Job Code: CD3216 Project: Heyford Park
Village Centre

Date Issued: 27/3/2018 Revision: S2-P6

SCALE: As indicated	DRAWING SHEET SIZE: A1
JOB CODE: CD3216	DRAWING NUMBER: CRD-01-ZZ-DR- A-05031
REVISION: S2-C 3

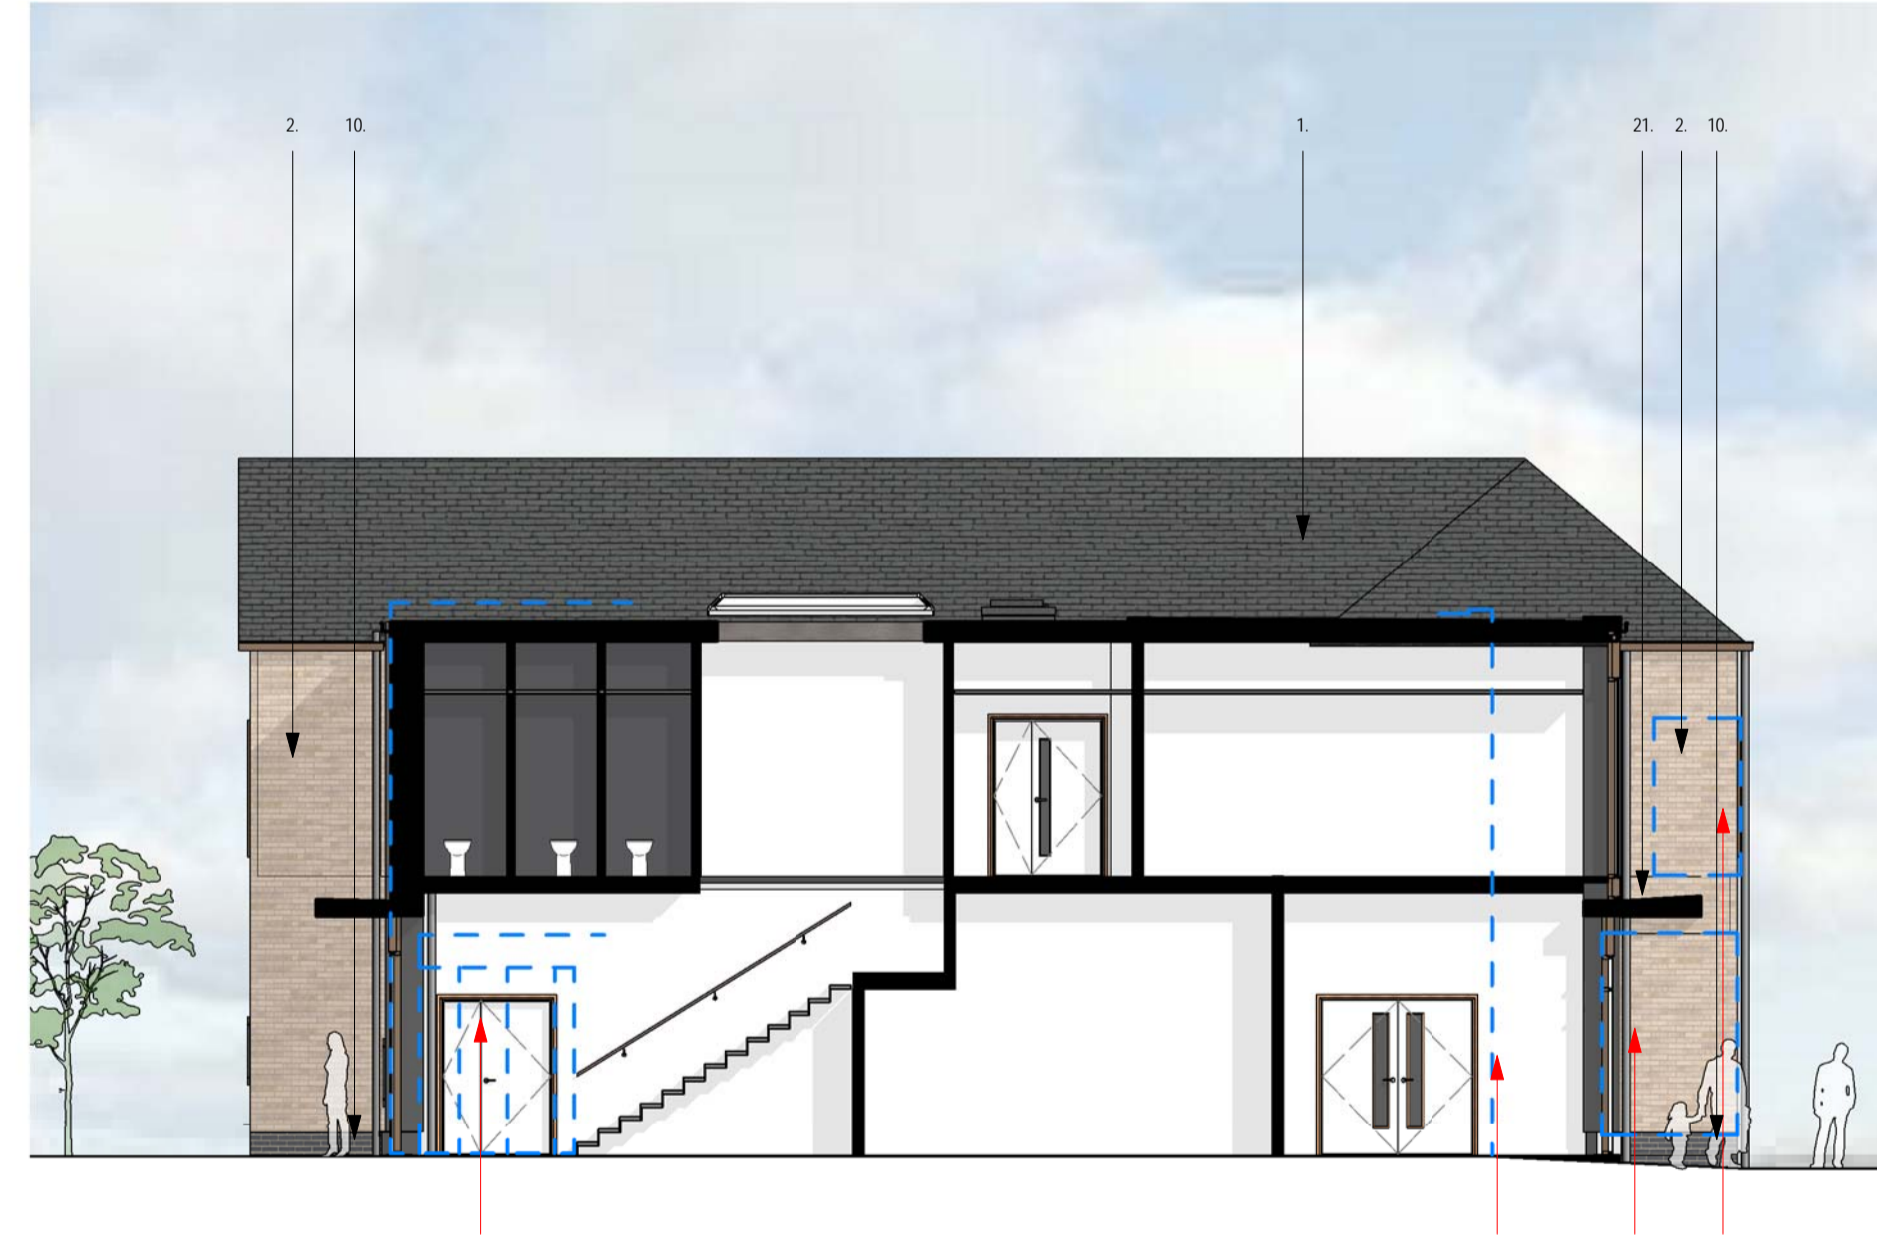
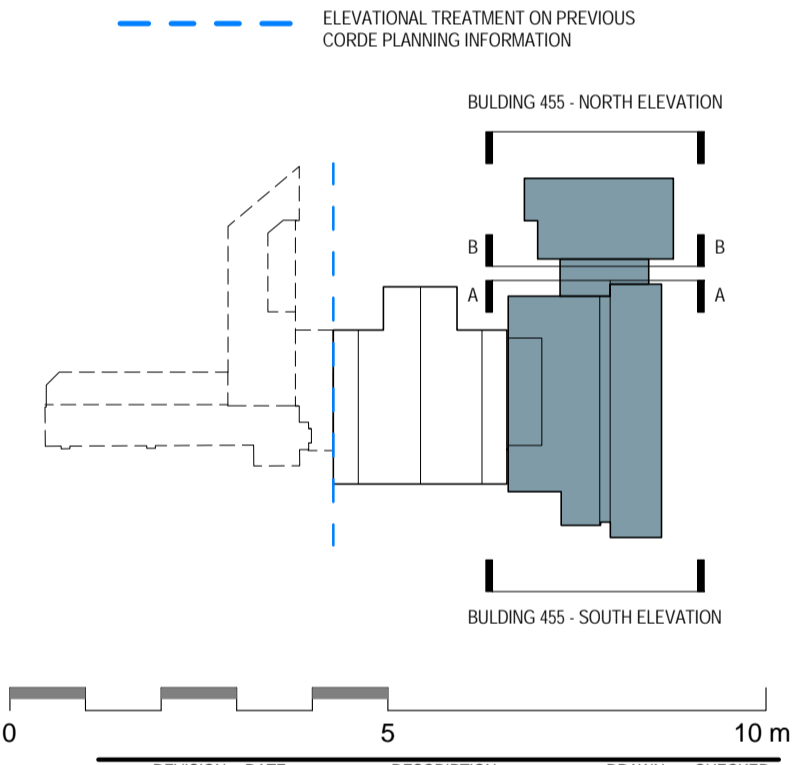
2.5	Protruding metal clad element and covered canopy omitted and replaced with a rendered element to break up the massing.
2.6	Building entrance relocated to a more central location. Entrance is now entrance to Hotel, Bar and Restaurant so internal circulation rationalised.

2.10	External door from screening room removed as is not necessary for fire escape purposes.
2.11	Bedroom window configuration revised to break up elevation further.

2.12	Screening room removed from scheme and reallocated area to public bar. Metal diamond cladding removed from corner elevation as no longer represents the activity behind.

2.13	Double height glazing to stair core removed and replaced with glazing on ground floor and diamond cladding above as no longer a stair core.
2.14	Brick replaced with white render to break up the mass along the courtyard elevation.

2.15	Double height curtain walling removed and replaced with smaller modules.
2.16	External canopy to rear entrance reduced in length.
2.17	Glazing replaced with brickwork to prevent overlooking into bedroom from the new adjacent gym space.
2.18	Lantern roof light added over stair, following relocation of stair core from perimeter.
3.0	Building 457
3.1	Building 457 removed from this phase of works.
4.0	Covered Link
4.1	Temporary wall to end added following removal of Building 457 from this phase of works
4.2	Level change Canopy Link removed and one level surface created due to level threshold to Building 457 no longer required. Vehicle access doors reduced in number to suit
4.3	Depth of overhanging roof reduced on the south elevation.

SCALE: As indicated	DRAWING SHEET SIZE: A1
JOB CODE: CD3216	DRAWING NUMBER: CRD-01-ZZ-DR- A-05030
REVISION: S2-C 3

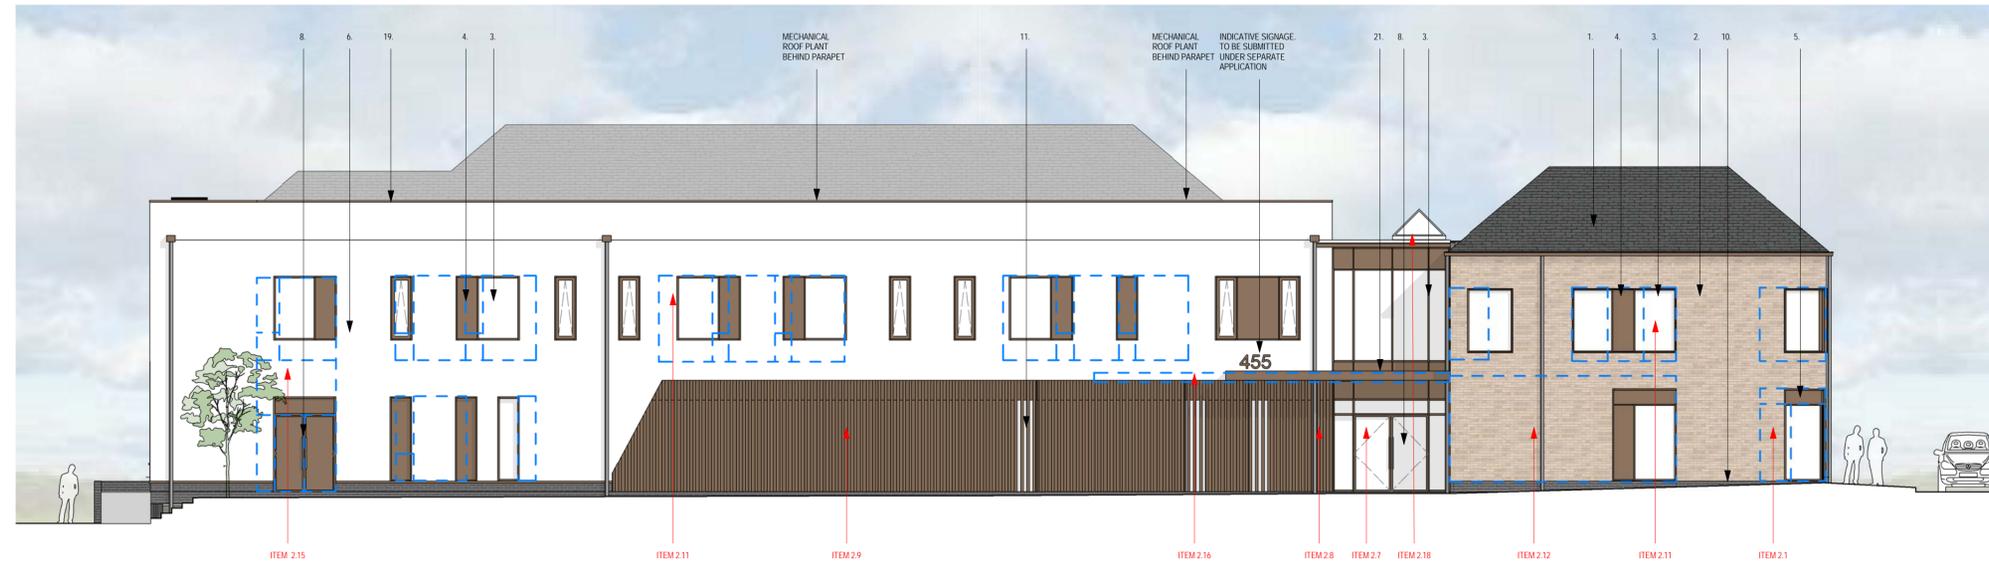
2.0	Building 455
2.1	Estate's Office removed from scheme to allow for large public bar to the front of Building 455. Access door from Camp Road removed and glazing to corner reduced.

2.2	Relocation of incoming Gas/ Electrical Meter Rooms at ground floor from Camp Road frontage to western car park. Louvered doors to Camp Road elevation now removed.

2.3	Expanse of glazing reconfigured along Camp Road to break up elevation.
2.4	Expanse of glazing increased on western façade to create greater orientation towards plaza and spill out of bar into plaza.

2.7	Building's glazed rear entrance has been brought forward to align with bowling alley glazing line. Bronze panels added to floor plate area.
2.8	Curved glazing to bowling alley removed as entrance lobby line has been brought forward to align with bowling alley glazing.

2.9	Continuous Curtain walling behind vertical fins along bowling alley removed and replaced with rainscreen cladding and occasional slot glazing behind.

DRAWING TITLE:
PROPOSED BUILDING SITE PLAN

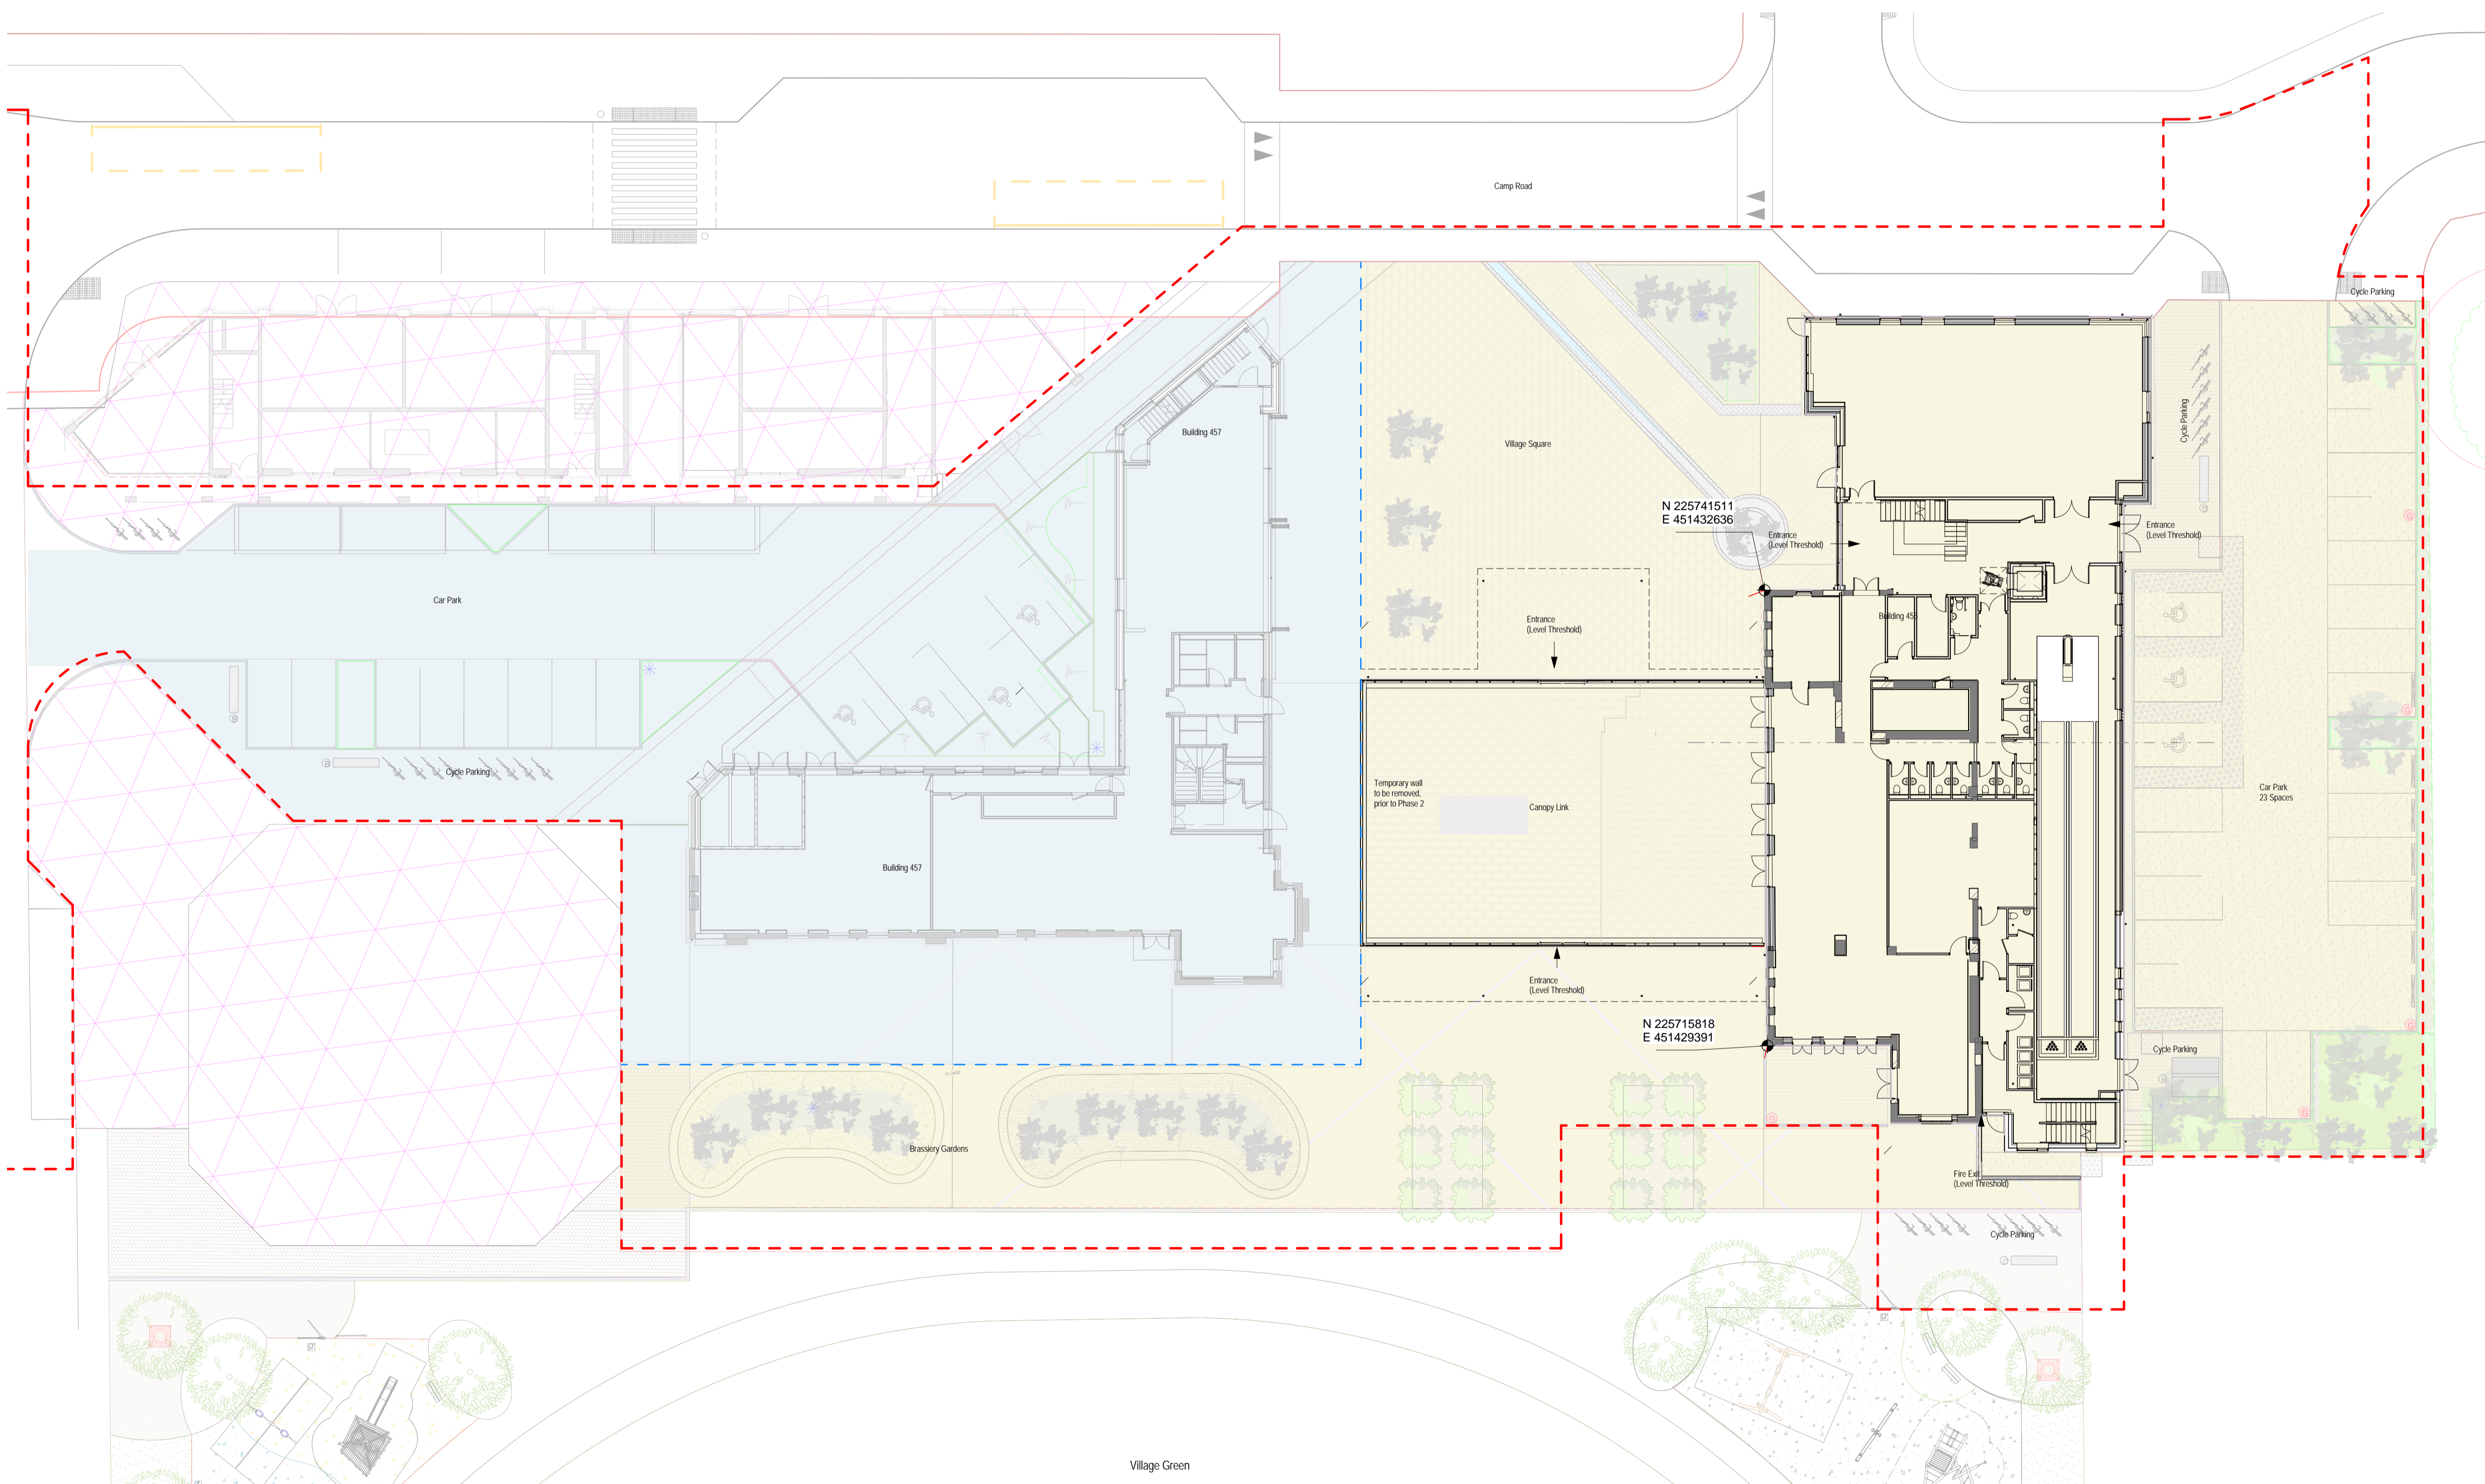
Item Ref.	Description of Design Amendments
1.0	Village Centre Generally
1.1	Building 457 removed from this phase of works. Inclusion of ancillary bar and restaurant to Hotel within Building 455.
